From: Michael Eastham
Sent: 21 March 2018 12:26
To: Planning.Responses
Subject: FW: 4485 - Courtwick Littlehampton - variation of conditions 4 & 24 - Ref LU/408/17/PL

Would you like "Drawing Number 4485/314 Rev. E – North Eastern Footpath Link Details Plan" to be listed as an additional plan in the varied Condition 4, which was imposed on the outline planning permission (LU/355/10/)?

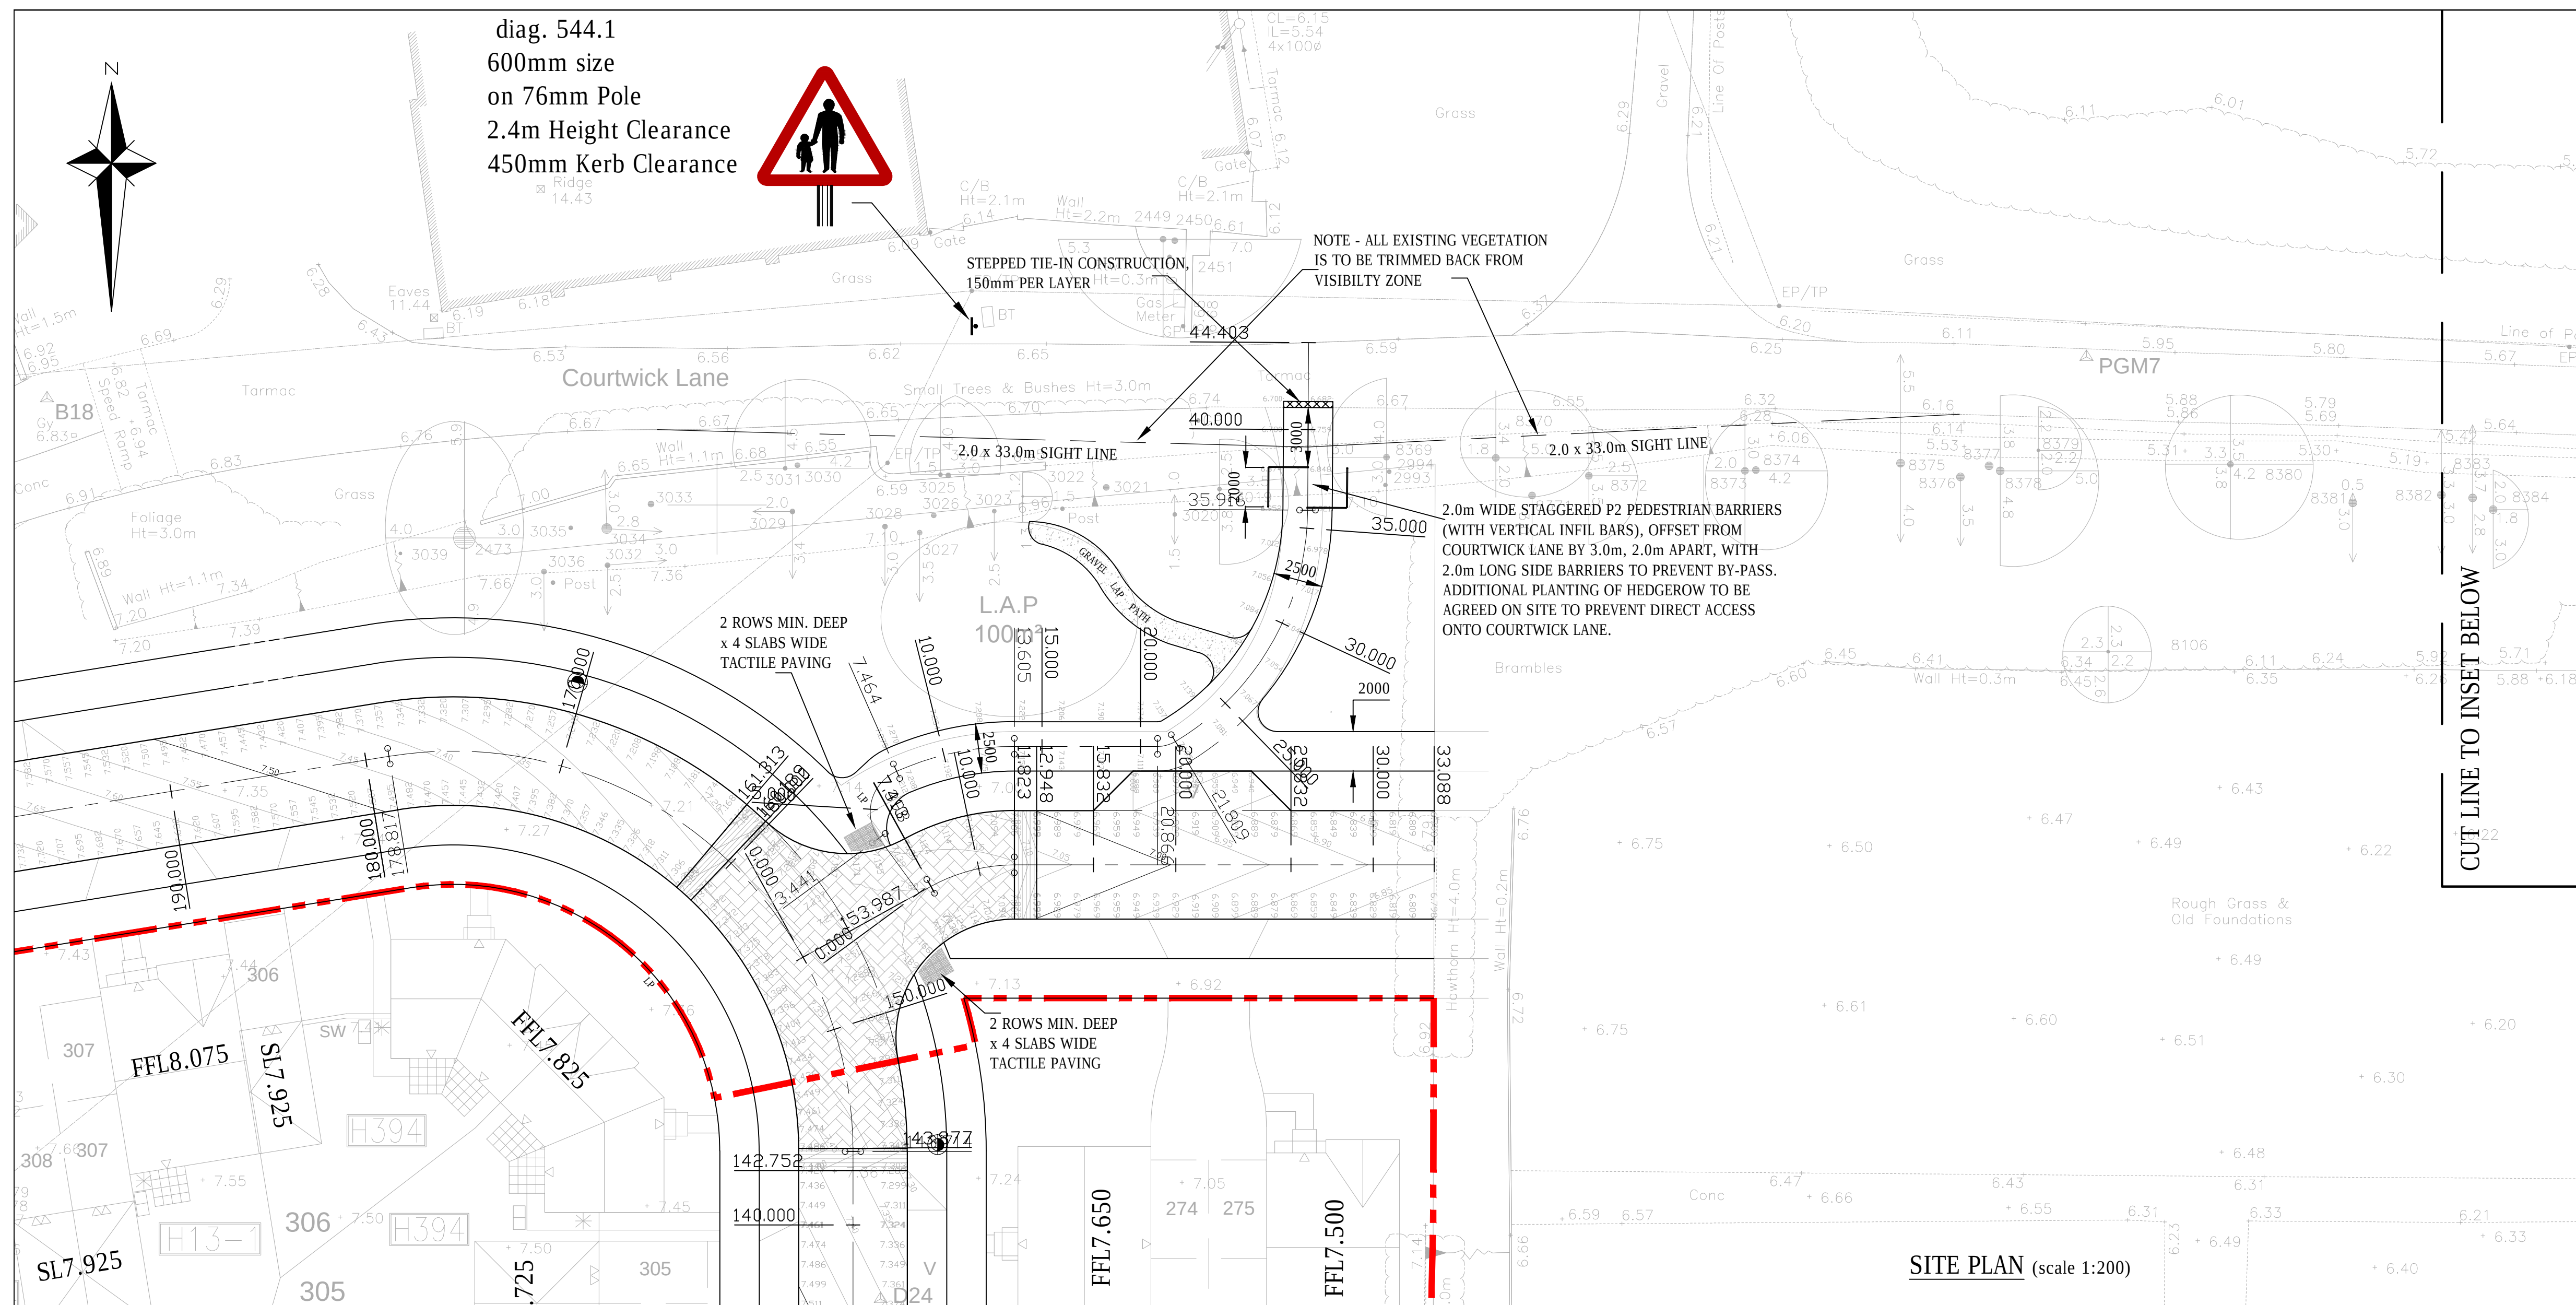
As far as I can see, the arrangements proposed by Bellway is still one that looks to be suited for cyclists. Furthermore, the stagger of the barriers might be the wrong-way-around and the use of hoops with 1200mm clearance underneath would permit a young child to walk or run underneath. They also might need to be a bit closer to the road (albeit not within the sight line splays). Finally, the gap in the middle would permit cyclists to traverse fairly quickly so should – I believe – be narrowed. However, the applicant would still have to demonstrate that those with pushchairs and mobility scooters can get through them. Sustrans guidance might assist here (*SEE LINK BELOW). Finally, there must be barriers (e.g. fence) either side to prevent the gates from being by-passed. In any event, appropriate design guidance will have to inform the final solution. However, it is still unclear what design guidance they have used to inform the proposal as the extract that you/they have provided is not one I have seen before. This should still be clarified, please.

Thank you Michael. This now appears acceptable.

Yes please list the drawing, however it is now revision F.

See attached drawings updated to reflect Tim's last comments.
